Application No: LU/295/20/PL
Site Address: 15 Beach Road Littlehampton BN17 5HZ
Description of works: Full planning application incorporating permitted change of use of part of existing office (A2 Professional & Financial Services) & use to form 2 No. dwellings (C3 Dwelling houses) on the two upper floors (resubmission following LU/107/20/PL). This site is in CIL Zone 4 (Zero Rated) as flats.

Thank you for your internet representation made on 11th November 2020 which has been recorded as an objection with the comments as follows:

SCALE / 1:100 @ A3
DATE / 30.03.2020
DWG. NO / 080616/TP.02.REV. 'C'

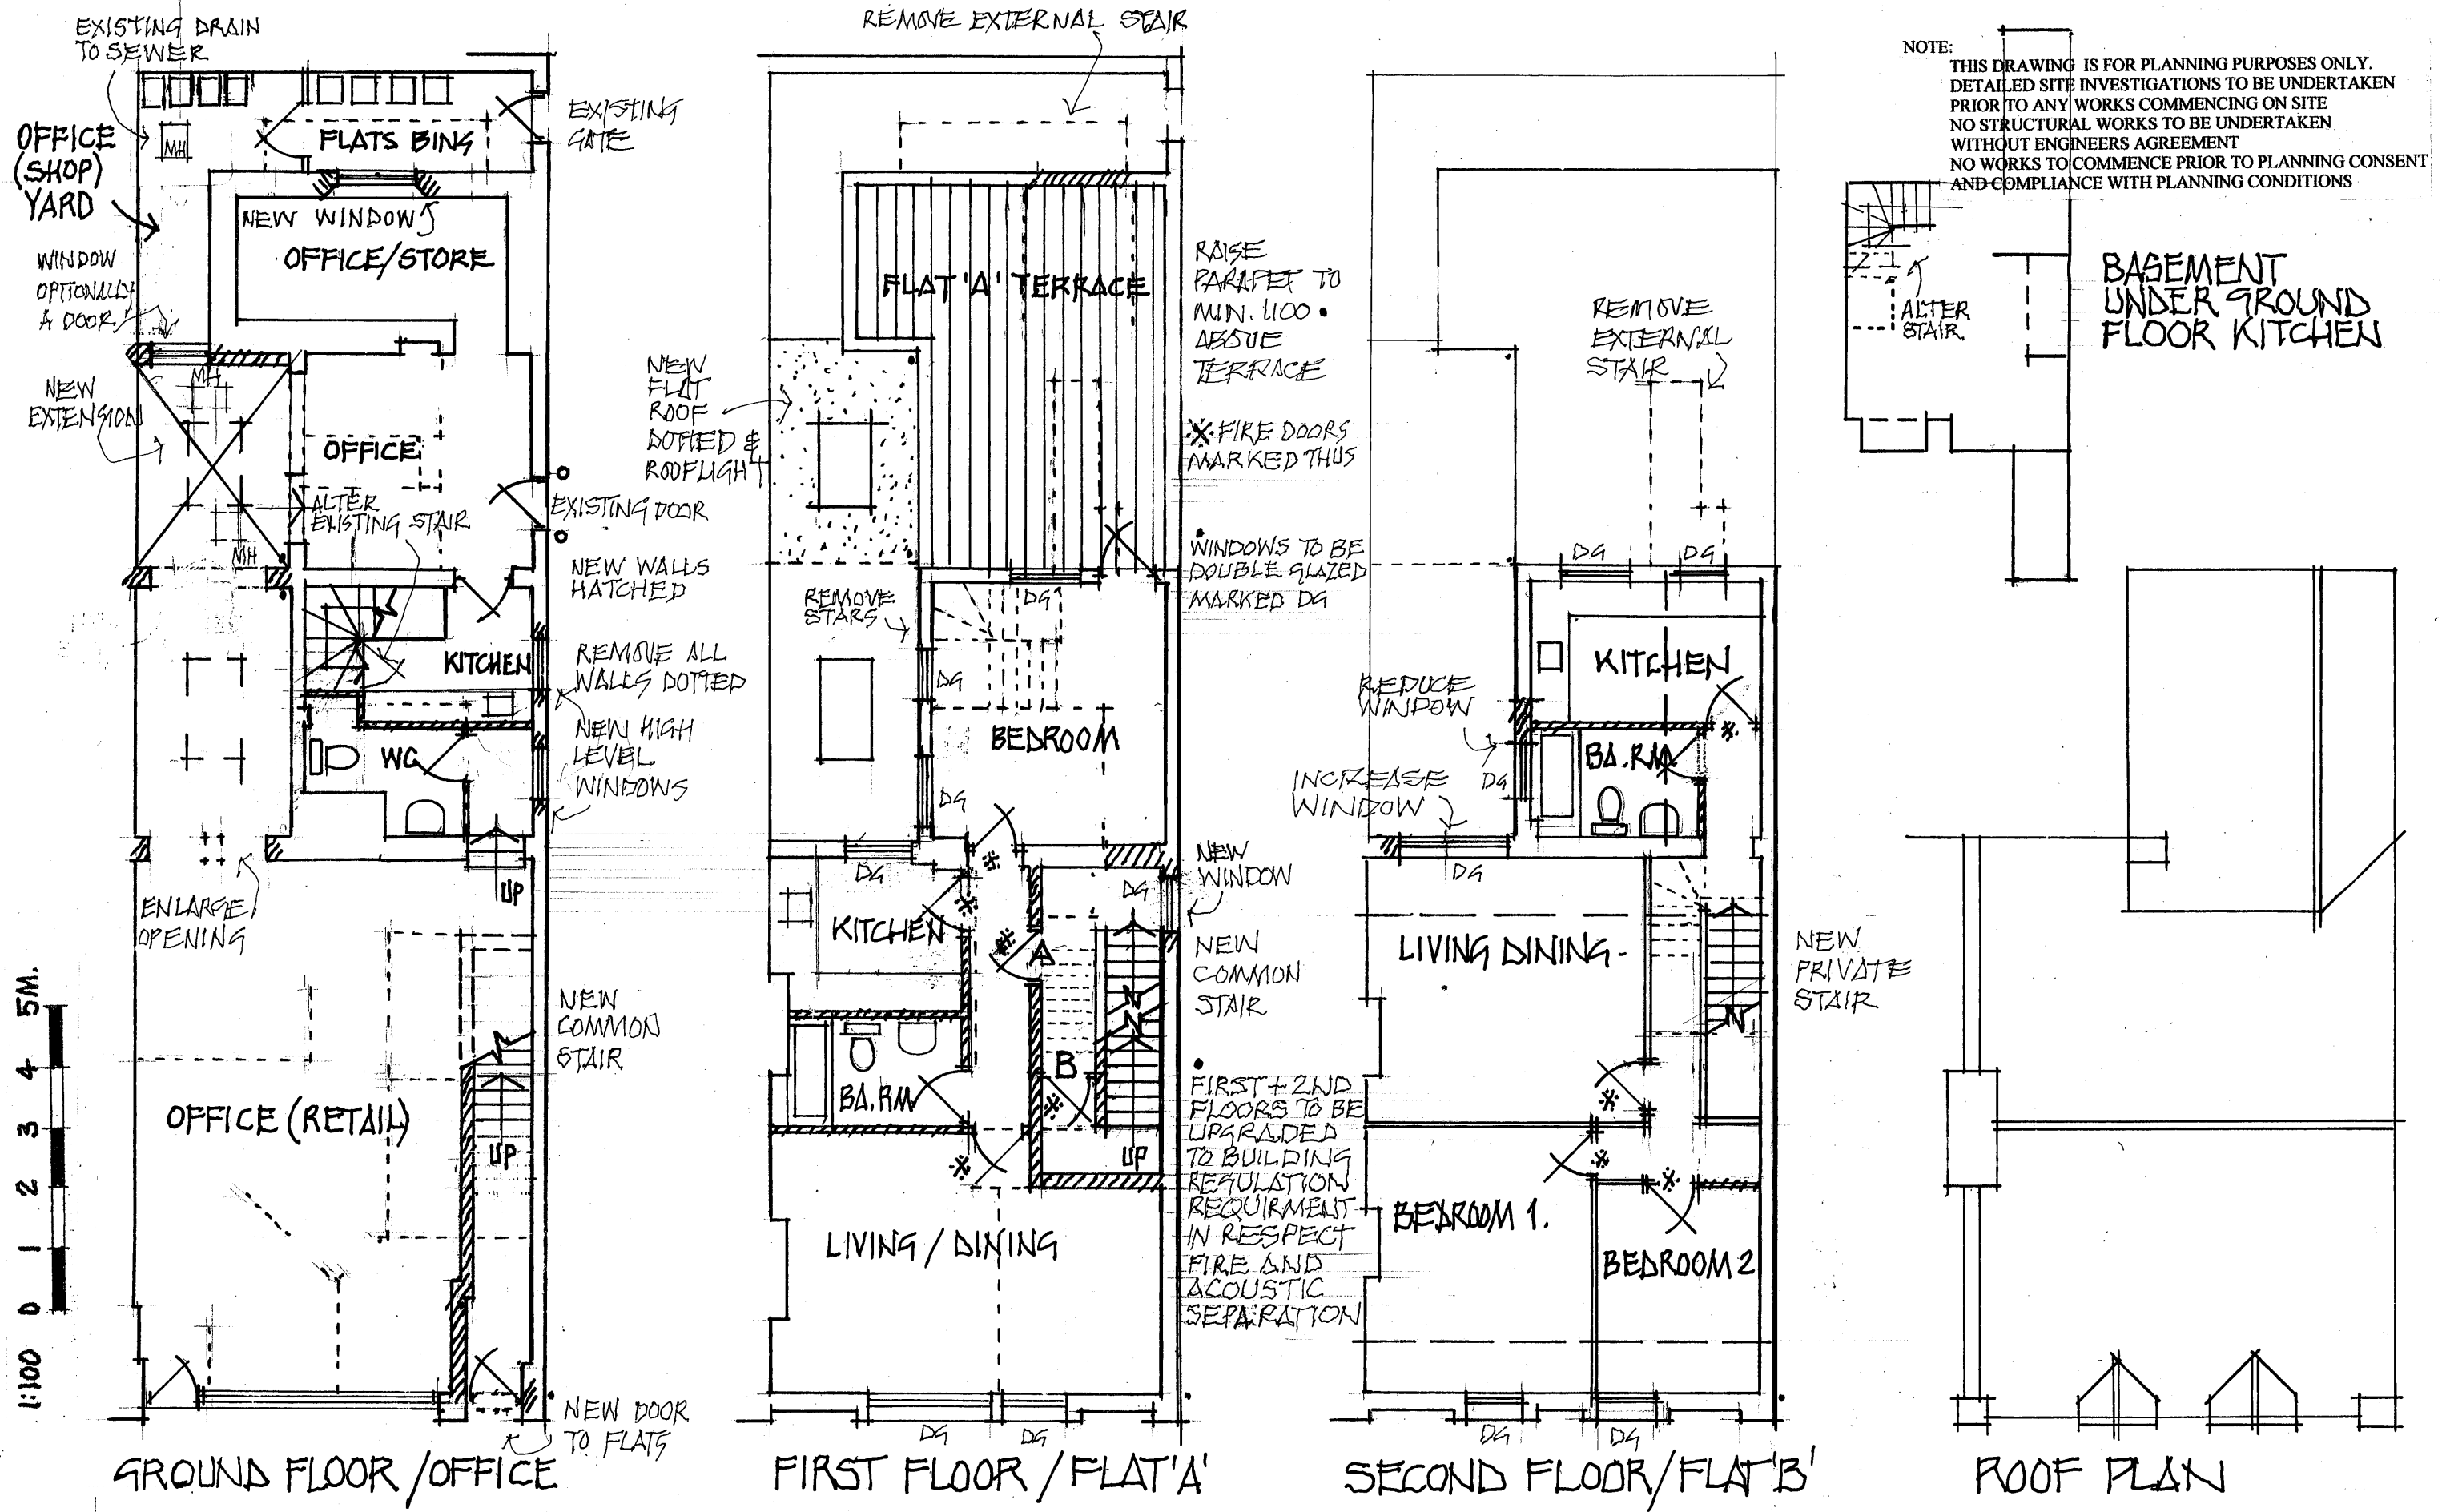
The Town Council's Planning and Transportation Committee considered this matter at its meeting held on Monday 9th November 2020 and objected to the application. It was observed that an internal stairway had been introduced, but that bin storage was limited and that there was no cycle storage. In view of the Town Centre location, Members considered these important and wished to see better storage provision to avoid the stairway being used and potentially causing a hazard.
